30 September 2024

Re: Amended Proposal SSD-66826207 - Mixed-use Development - 391-423 Pacific Highway, 3-15 Falcon Street and 8 Alexander Street, Crows Nest (Five Ways)

Council has reviewed these documents and offers the following comments which should be read as an addendum to Councils original submission dated 6 June 2024:

Project Title
Fiveways Crows Nest
 391/423 Pacific Hwy Crows Nest NSW 2065 Australia
 Drawing Title
**GA Sections
Section AA**

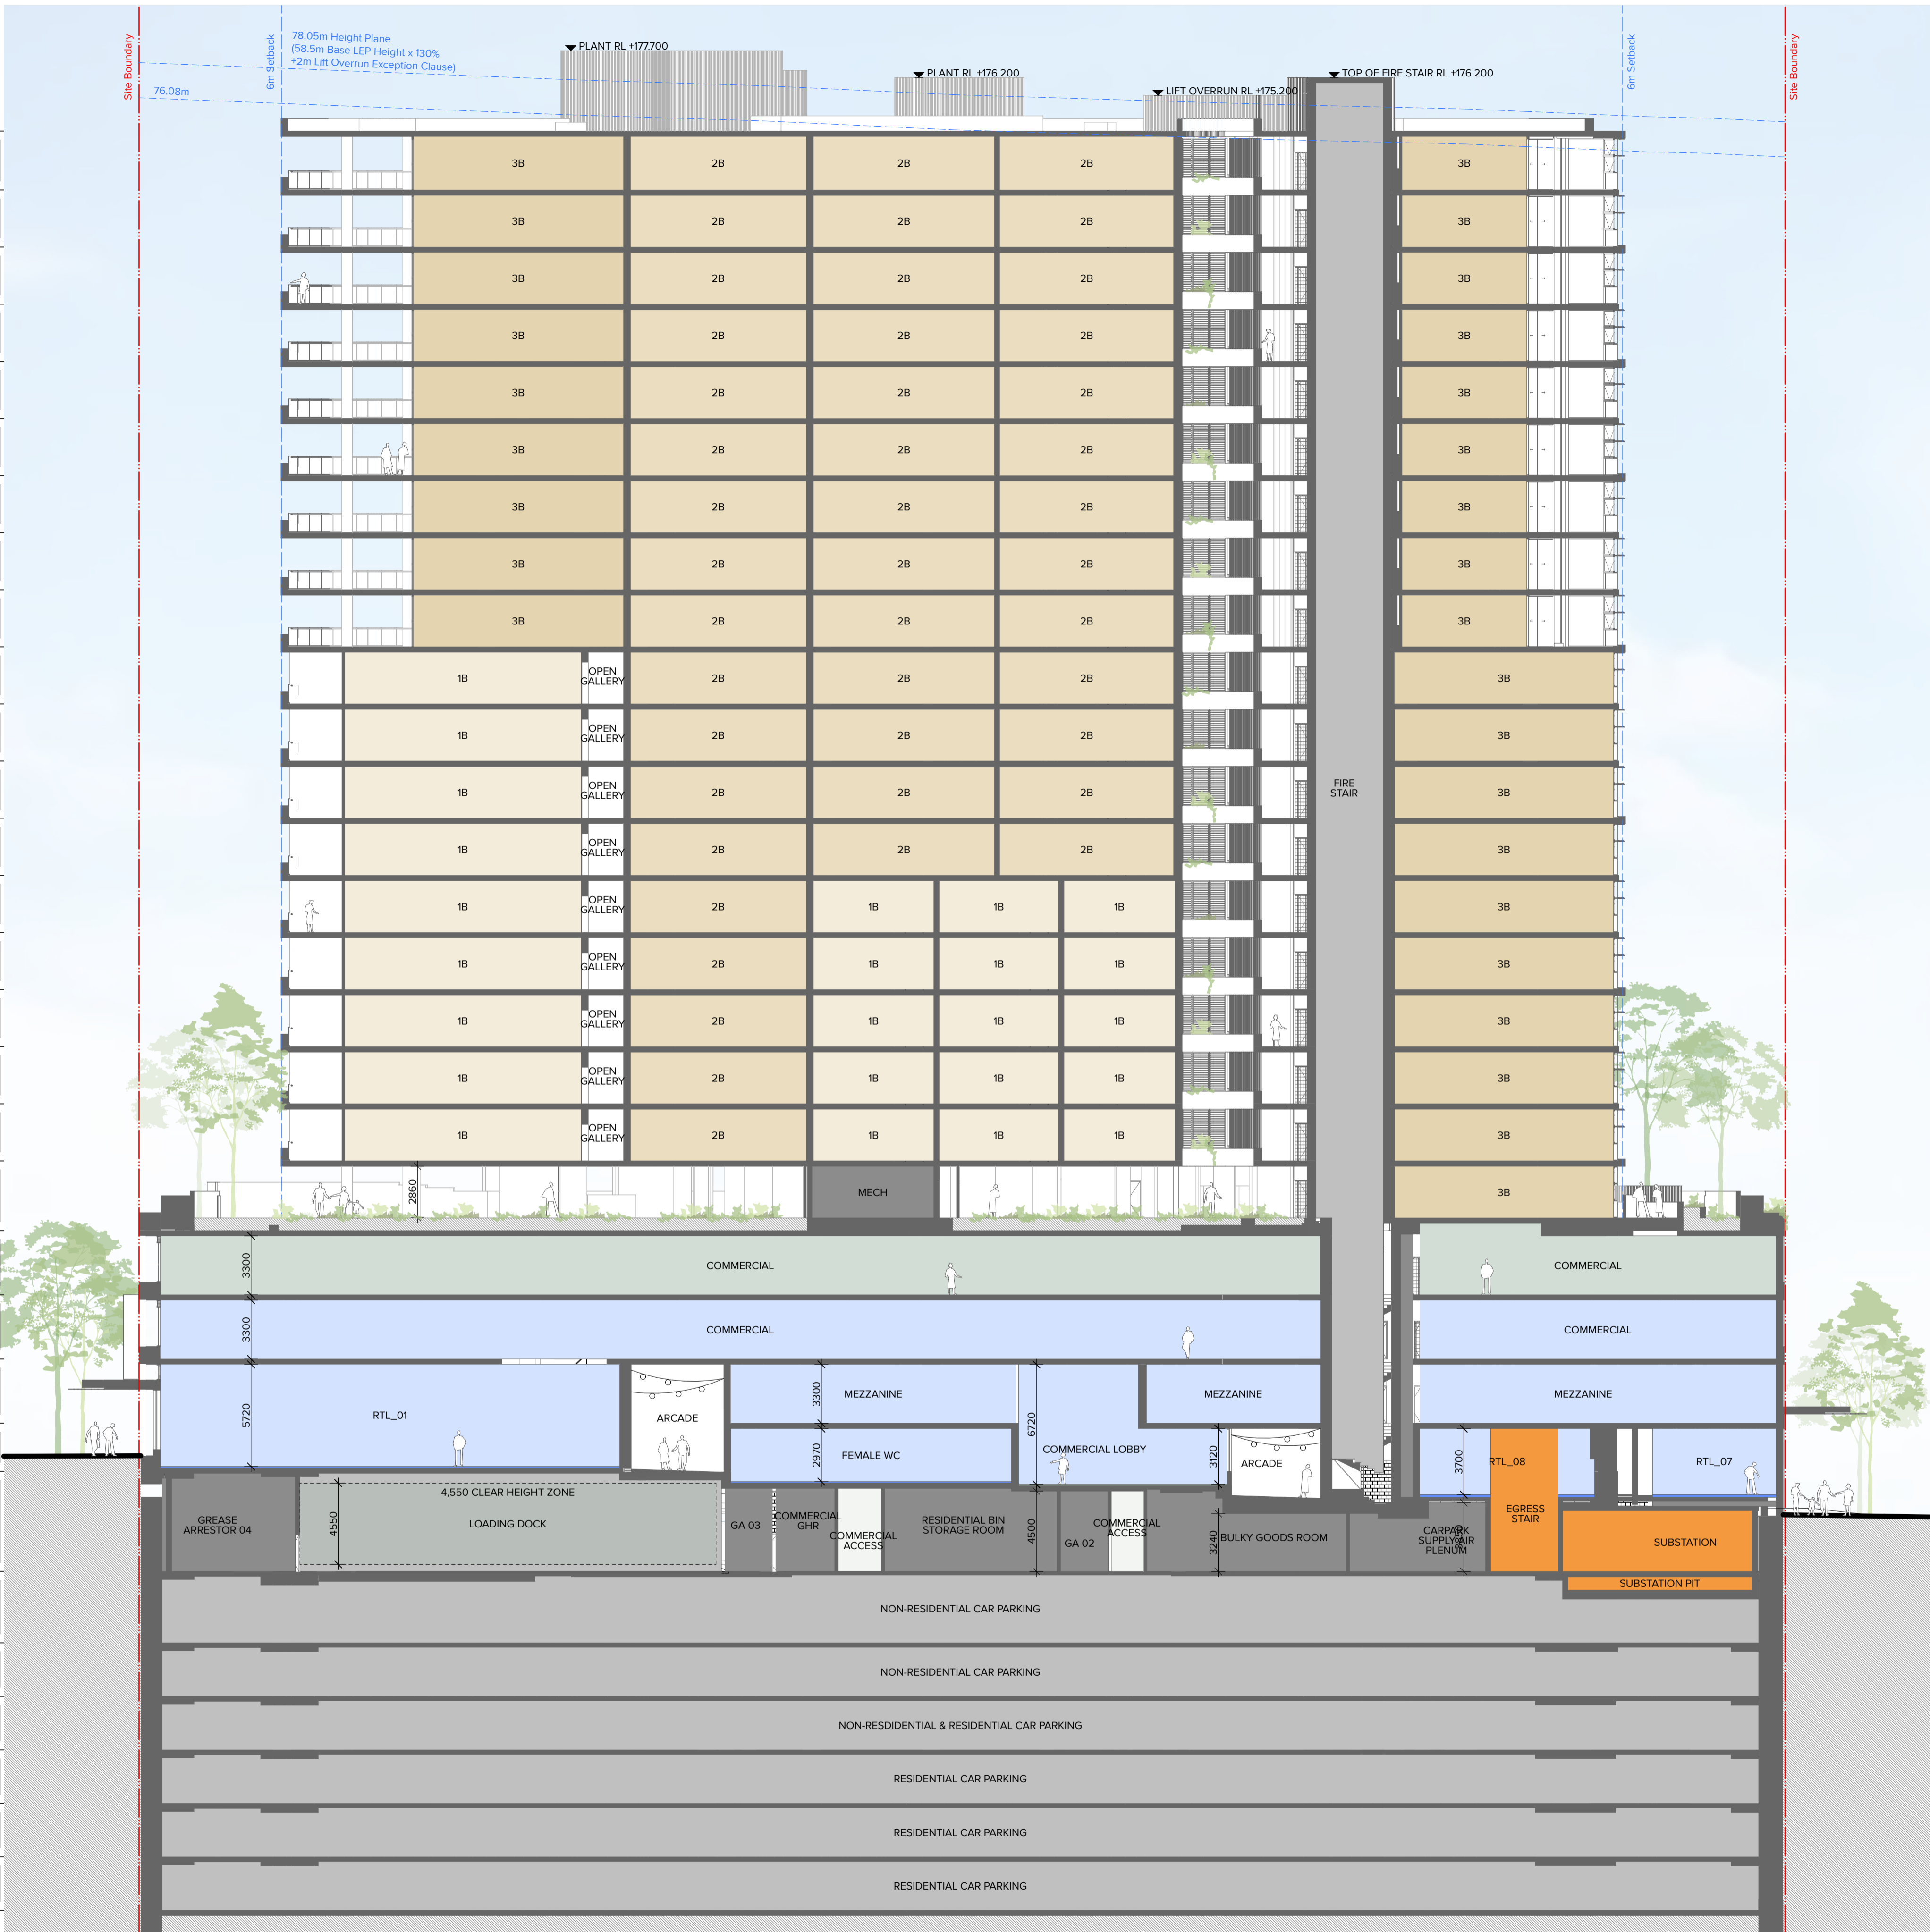
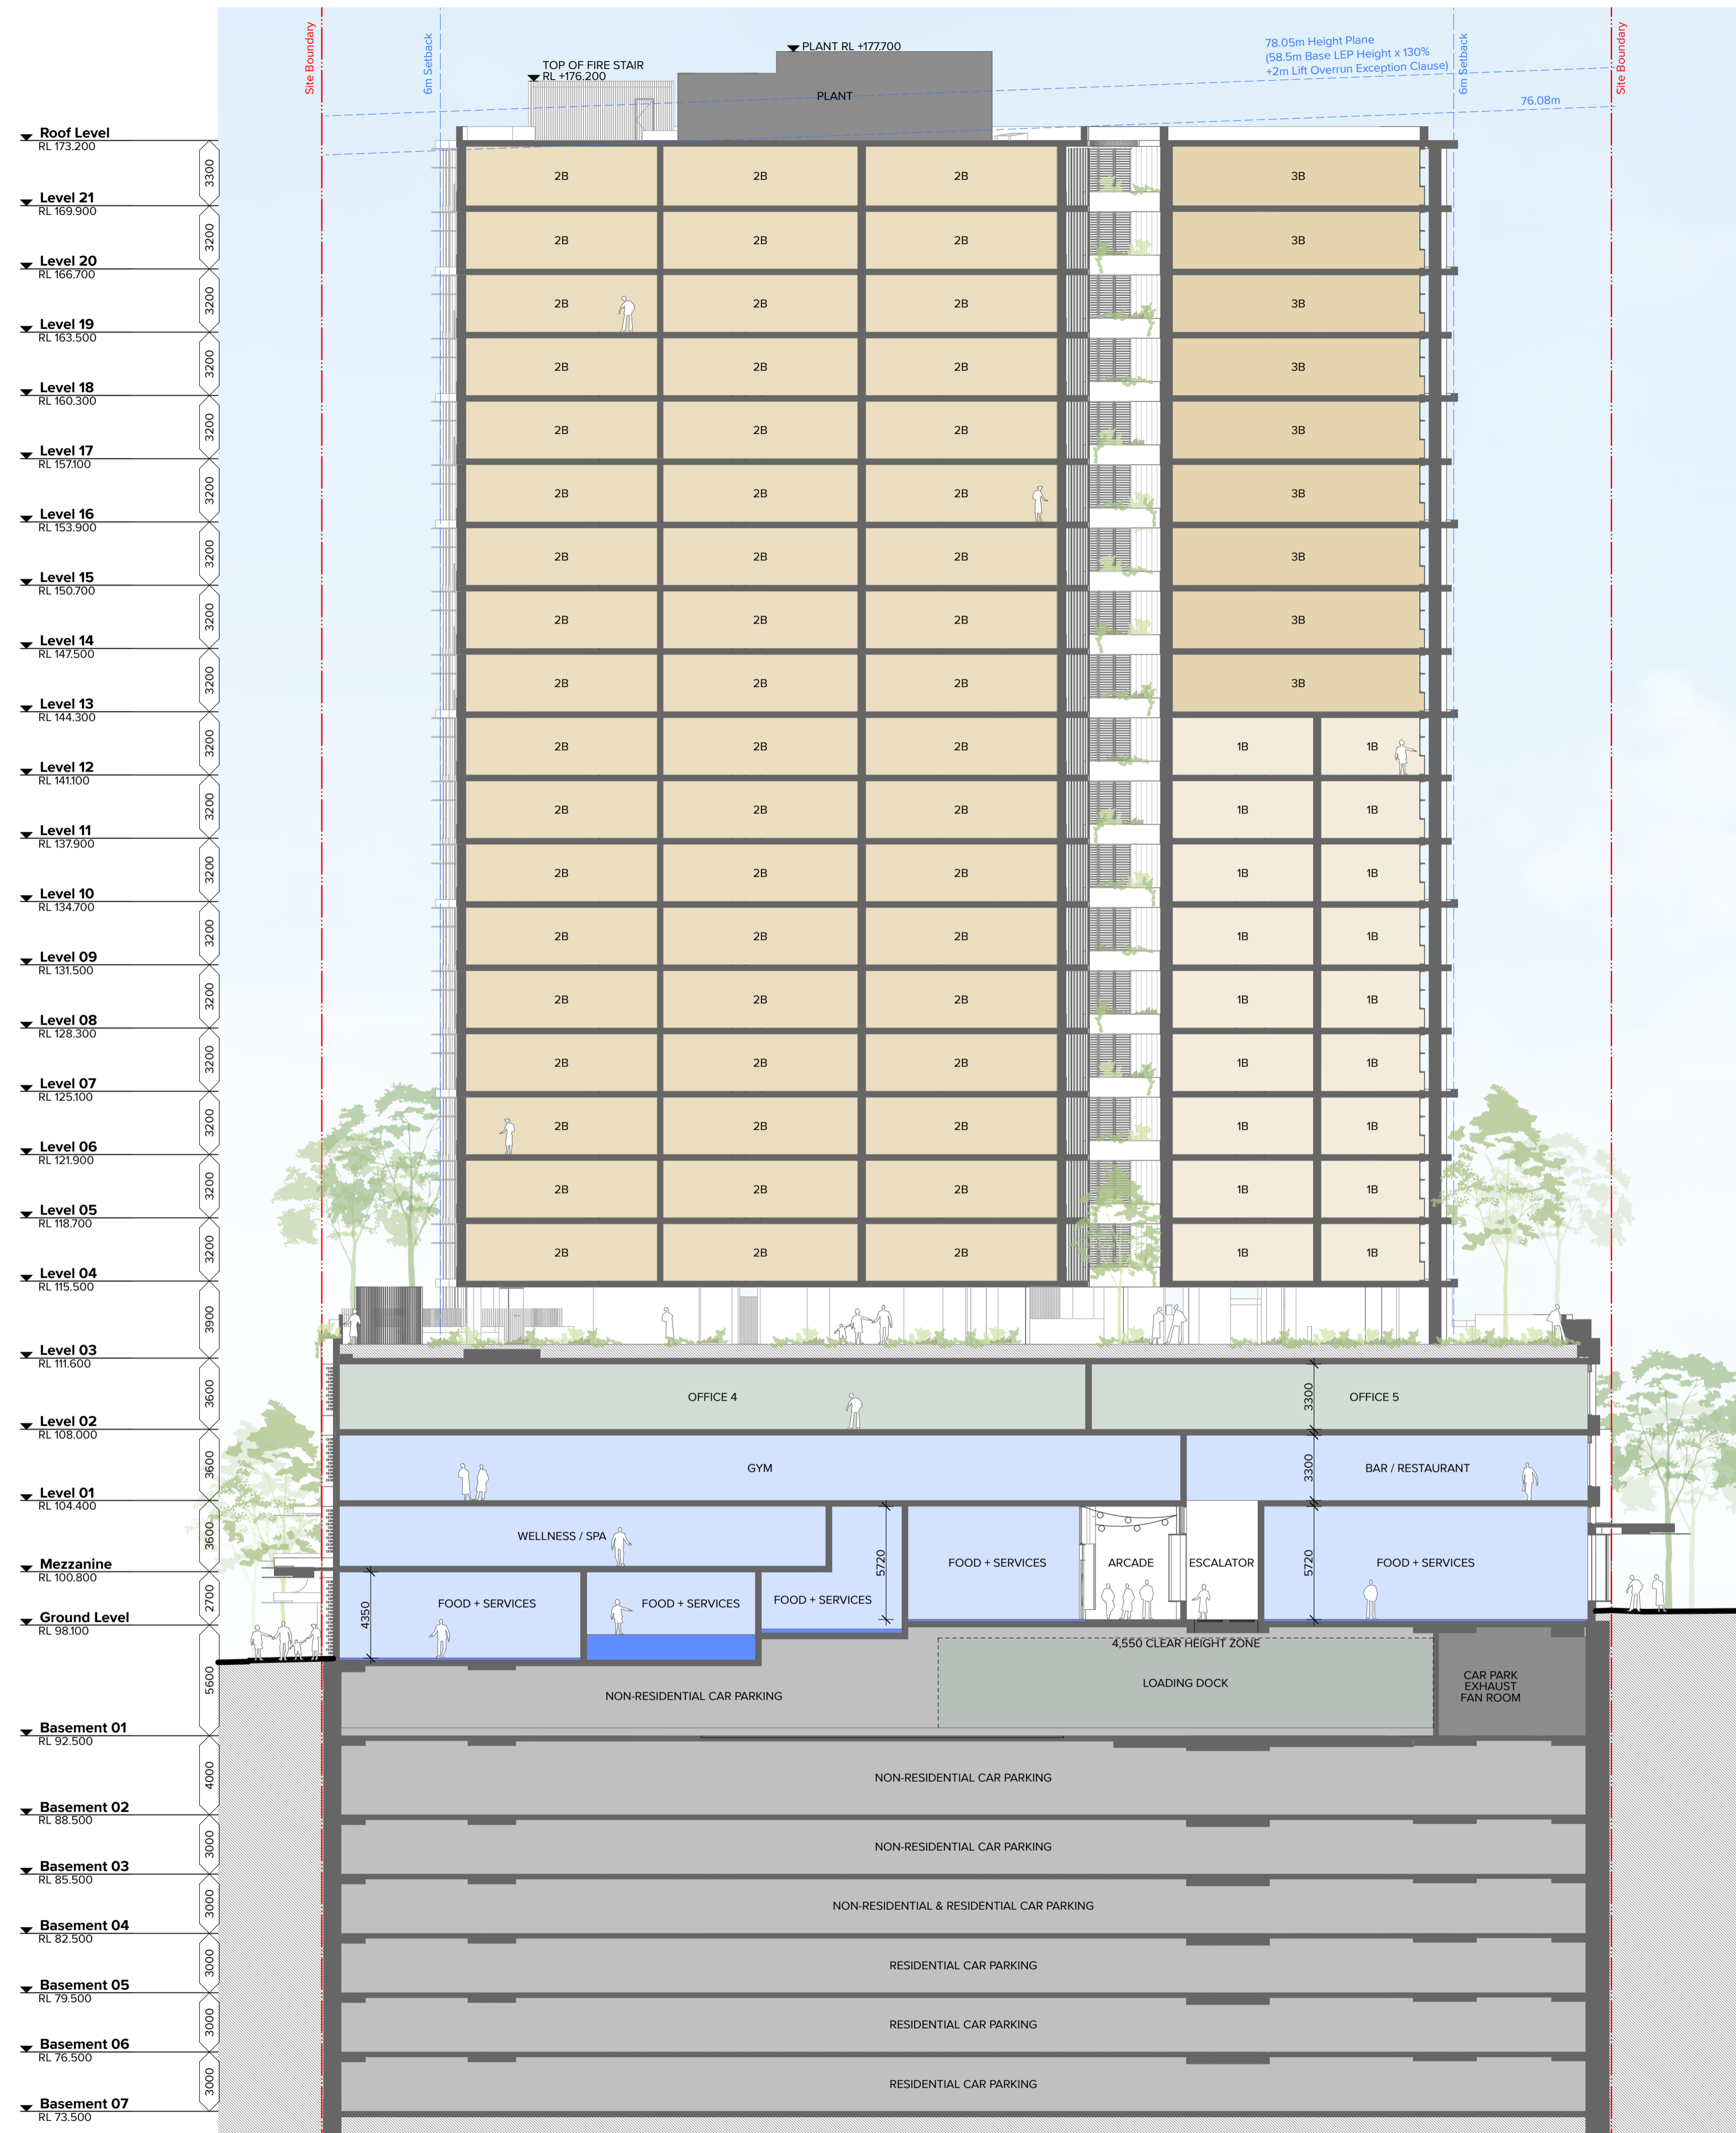
Council notes the increase in building height with no increase in the number of stories arising from the need to achieve a 3.200 metre floor-to-floor height to meet construction requirements. However, this increases building height from 78.650m to 80.305m.

Building height remains a key issue and Council objects to any increase in building height. Building height should comply with the provisions of NSLEP 2013.

Reduce the proposed building height to sixteen storeys as mandated by current NSLEP 2013 provisions.
